TfNSW Reference: SYD21/00418/03  
Departments Reference: SSD-16928008

**EXHIBITION OF EIS – NEPEAN HOSPITAL REDEVELOPMENT PROJECT - STAGE 2 - 35-65  
DERBY STREET, KINGSWOOD**

TfNSW has reviewed the documentation provided for the abovementioned development and provides comments and recommendations in **Attachment A**.

Attachment 1 – Western Loading Dock Swept Paths

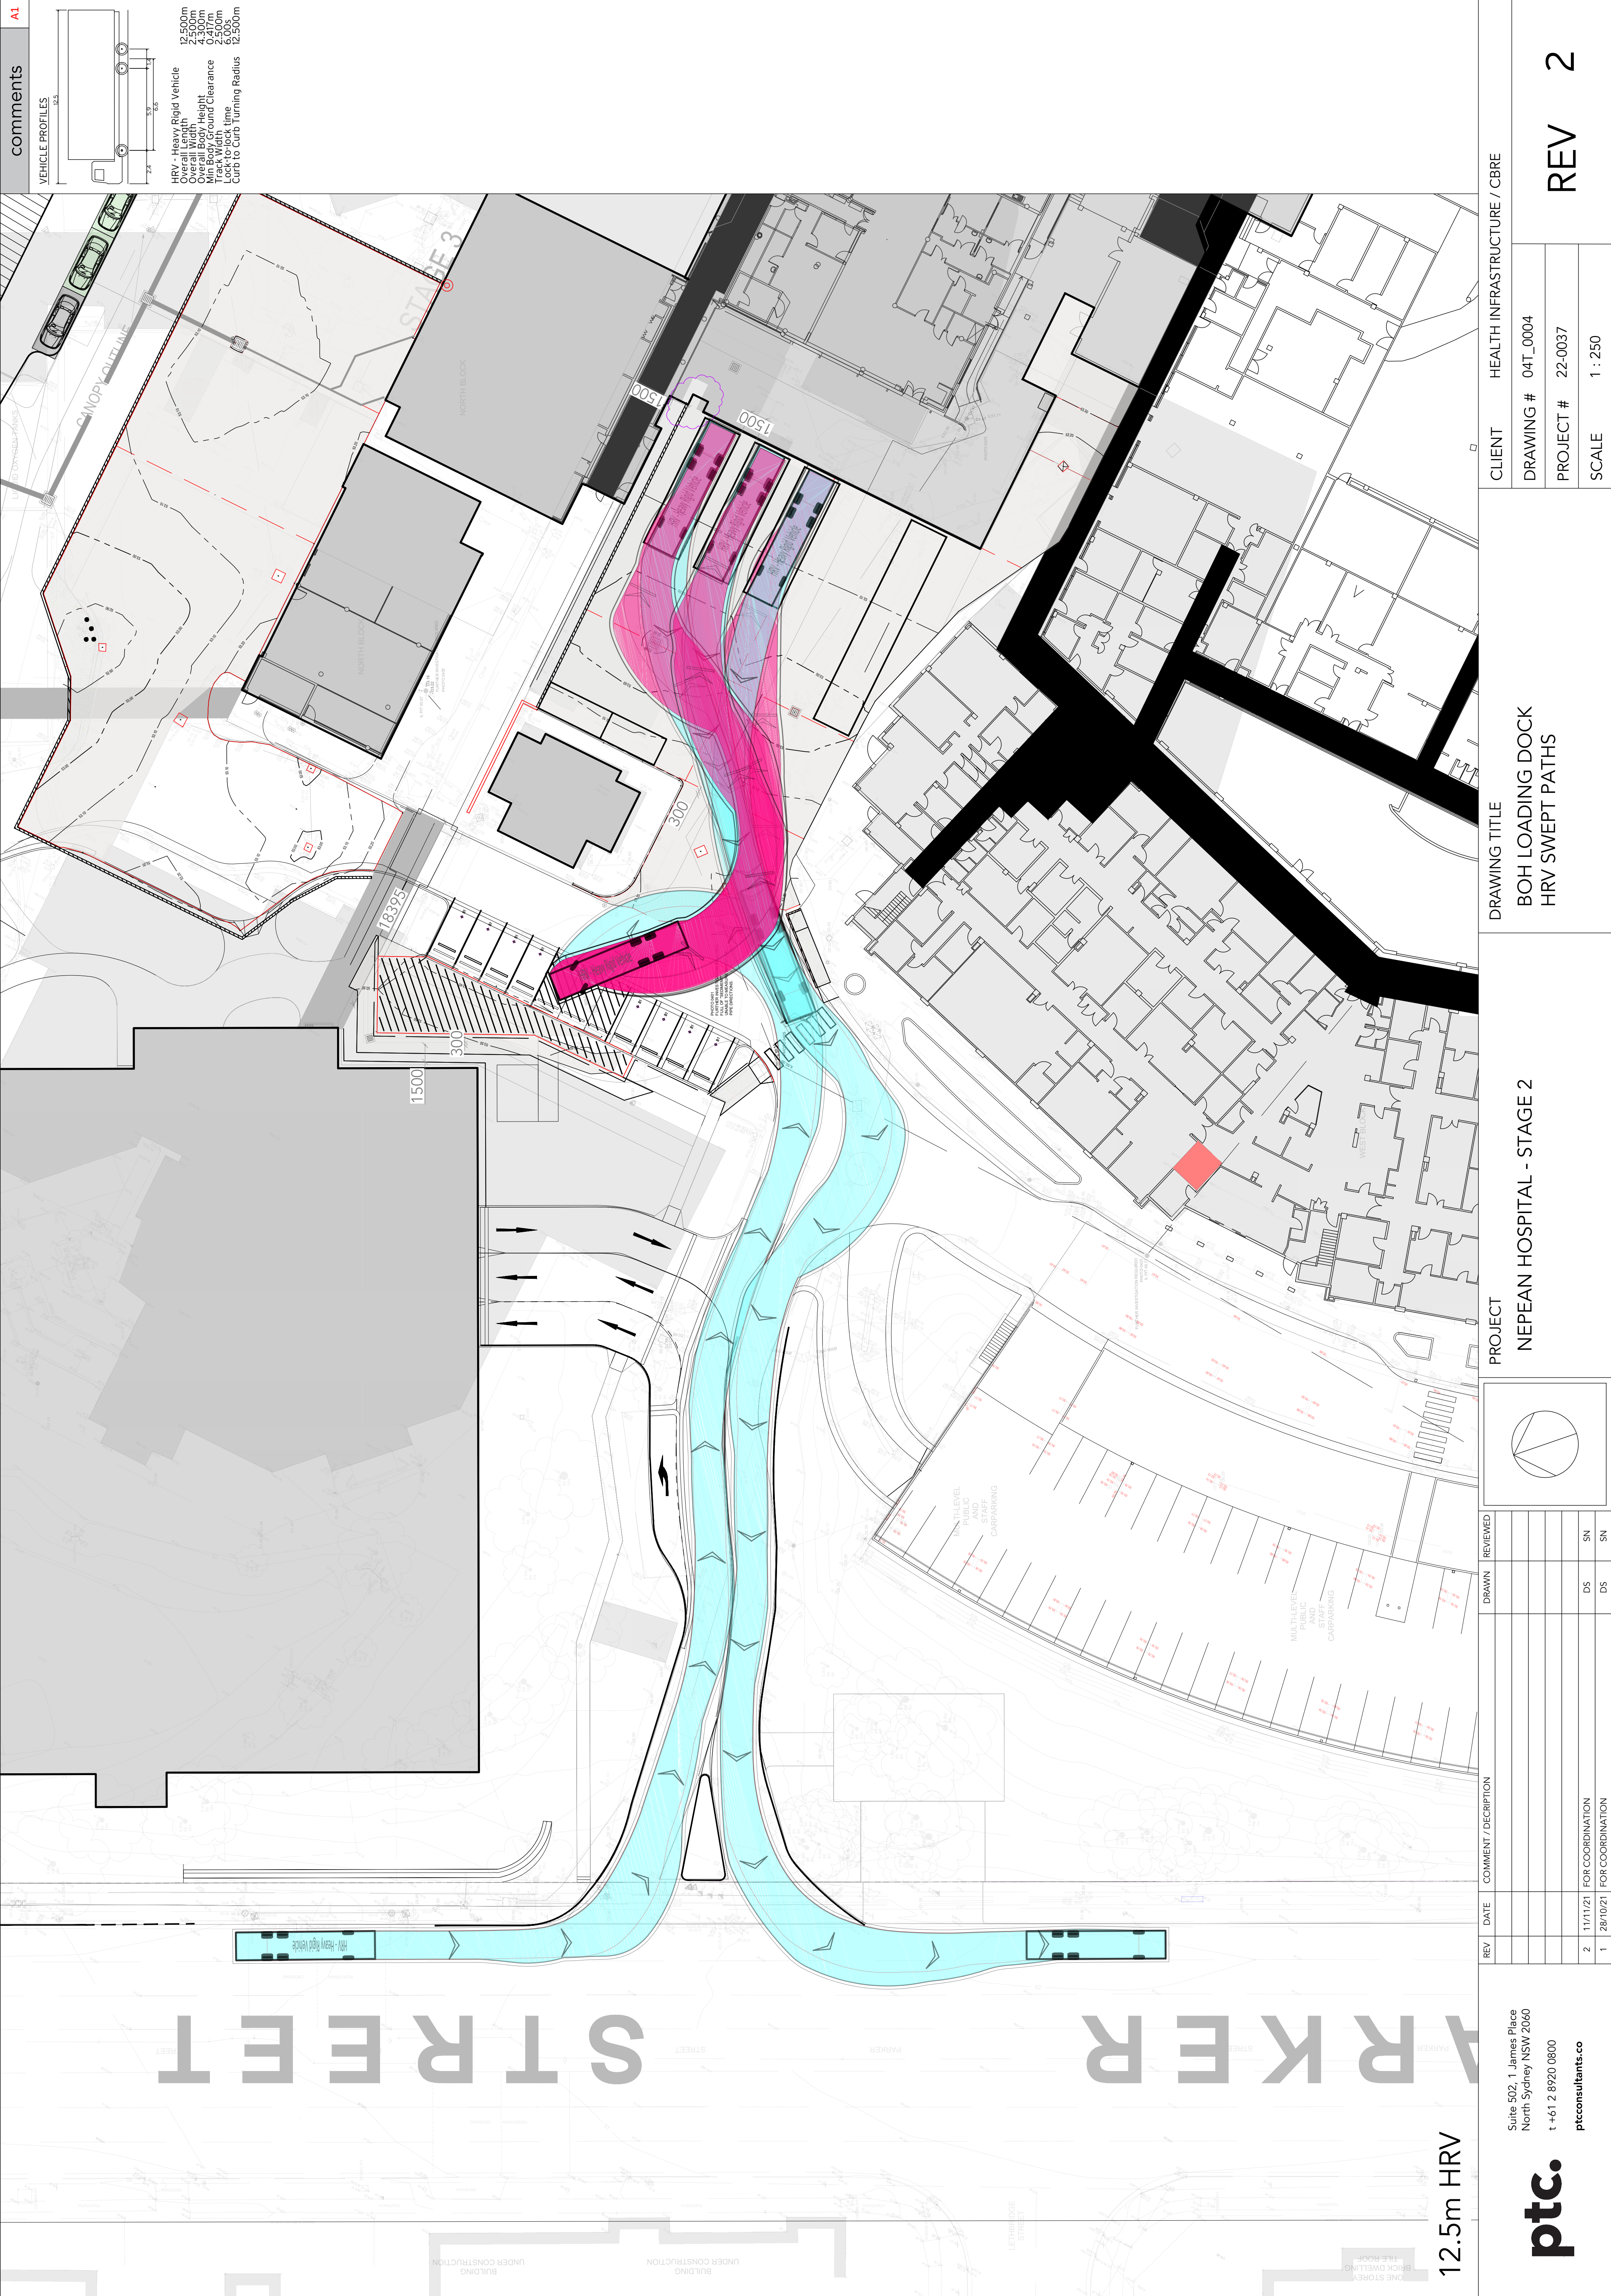
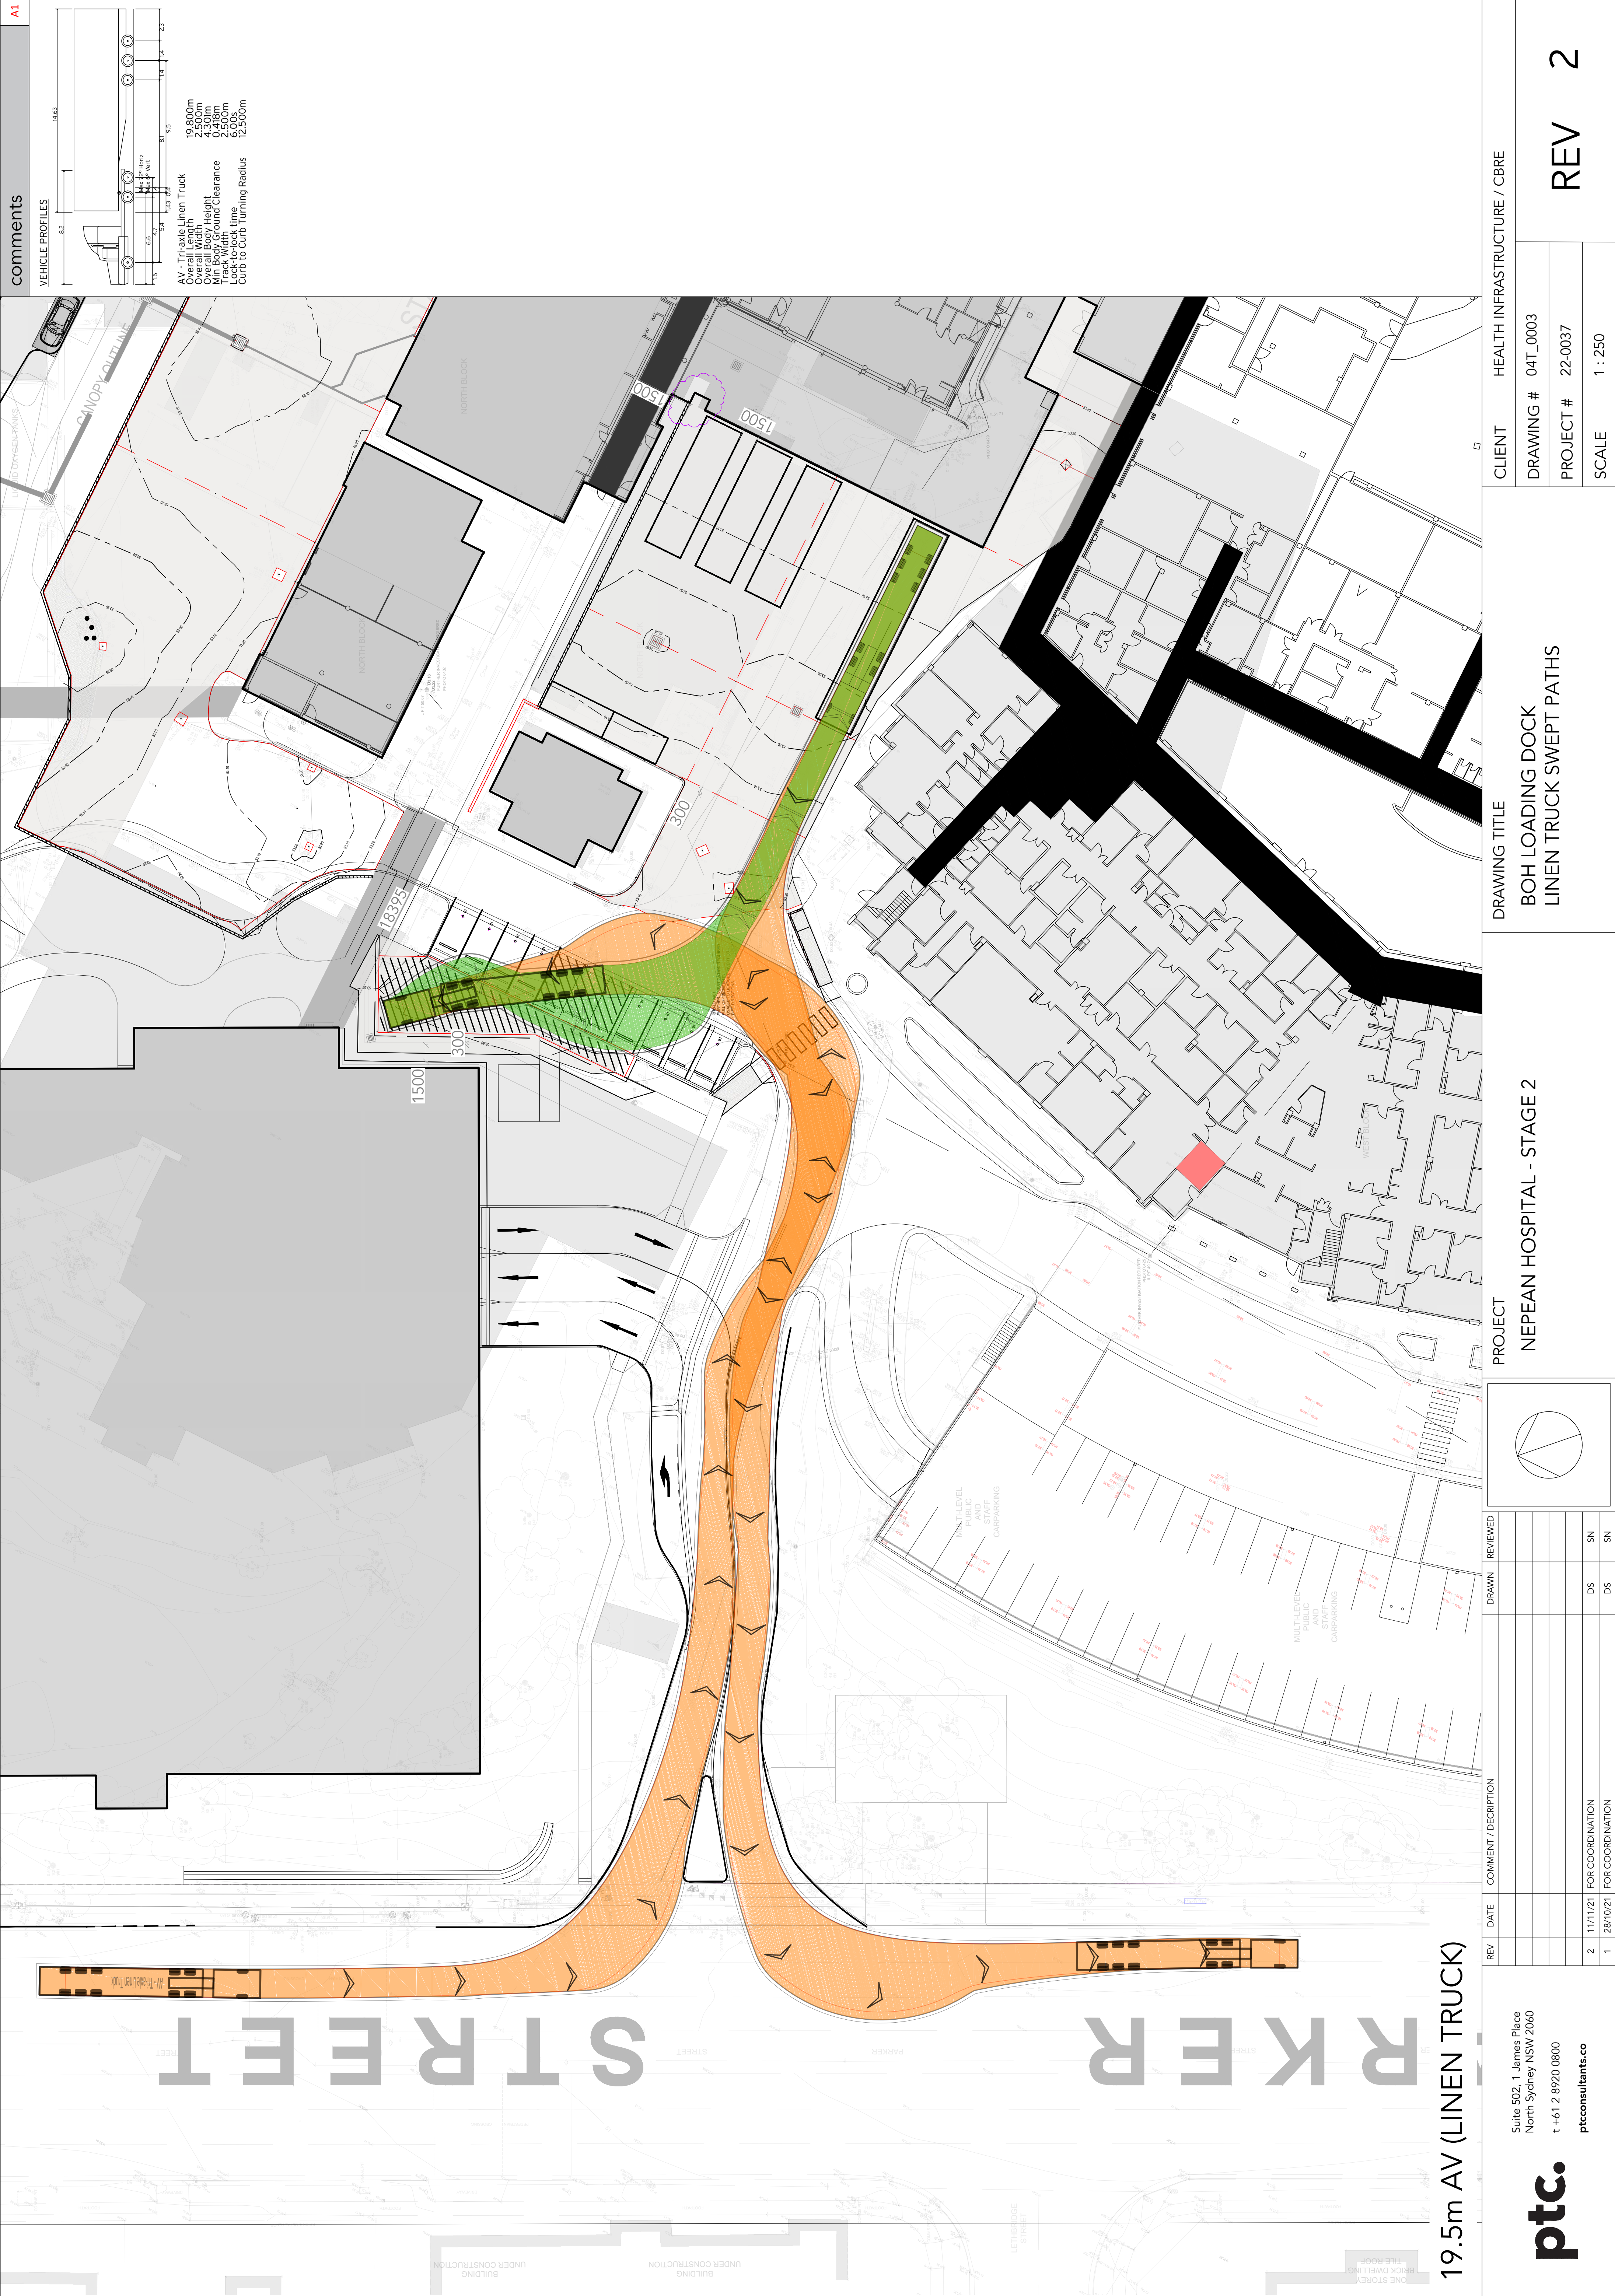
- i. Drawing #04T\_0004 – HRV reversing swept path indicates that truck will encroach into adjacent parking spot of hatched area. A parked vehicle would obstruct trucks ability to reverse into loading bay;
- ii. Drawing #04T\_0003 –
  - o Linen truck swept path appears to track over parking spaces – how will these spaces be kept empty to ensure that truck has clear swept path?
  - o Truck appears to turn from lane 2 on Parker St, truck should be straddling lanes 1 and 2 to ensure no vehicles can occupy lane 1 as vehicle turns left into Barber St
  - o Truck appears to use opposing traffic lane on Barber St upon entry – how is this safely being managed?

TfNSW requests the abovementioned information to be addressed/provided for further assessment prior to the determination of the application. TfNSW will further review and provide response upon receipt of the additional information.

Swept path plans should be in accordance with Austroads Standards and consider the following:

- o All vehicles are to enter and leave the site in a forward direction;
- o Simultaneous entry/exit to the site for the longest vehicles is to be achieved;
- o All vehicles are to be wholly contained on site before being required to stop;
- o The swept path of the longest vehicle (including garbage trucks, building maintenance vehicles and removalists) entering and exiting the subject sites, as well as manoeuvrability through the site, shall be in accordance with AUSTROADS;
- o Swept path diagrams should show linemarking and kerbs etc to see if the turning movements encroach the opposing direction of traffic / other parts of the shoulder/verge (i.e powerpole etc).
